RFI #: 73
Date: 3/12/2012
Job: EB-02 Keller Springs Lofts
Phone: 877-777-5115

Subject: Proper location of gas meter

RFI #: 184
Date: 8/23/2012
Job: EB-02 Keller Springs Lofts
Phone: 877-777-5115

Subject: New route of the domestic water line from the garage

SHEET
C10

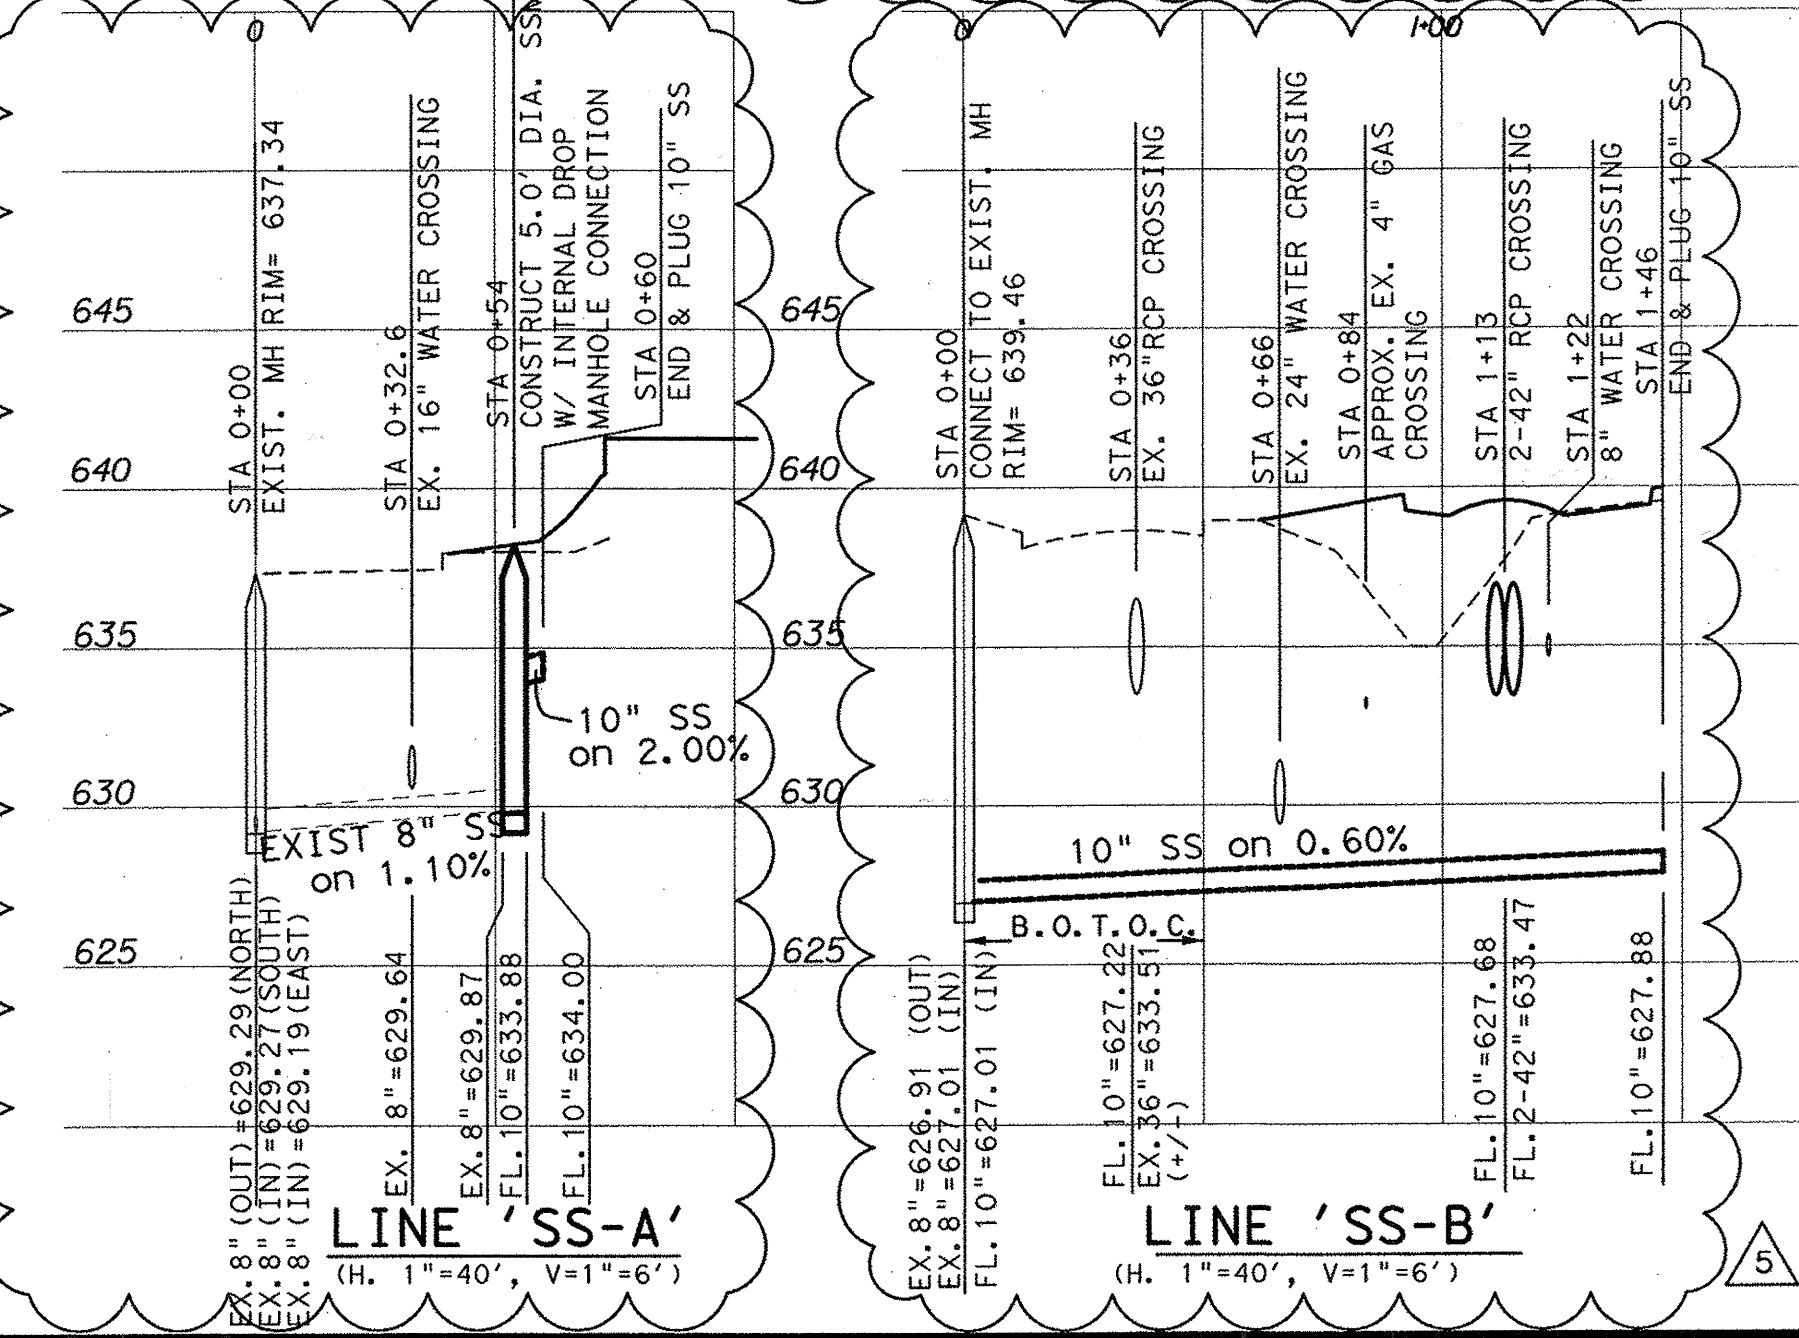
Request: Date Required: 3/12/2012
The location for the gas meter appears to have changed from its original location reflected on C 10 on the Civil Plans. The new location appears on the Jordan Skala SK-P1 dated 01-19-2012. It is on a completely different part of the building from C 10 and slightly different than P-3.1C. Attached is SK # 1 which is where it's located on C 10. SK # 2 reflects where I feel it is intended to be located. SK-P1 is the revised sketch by Jordan Skala locating it where we believe it is supposed to go. I need confirmation that it does go the way I show it on SK #2 and as shown on SK-P1.
Like I said, I need the surveyors to stake the proper location tomorrow.

Response:
The gas meter should be located in the spots shown on SK#2 and SK-P1.
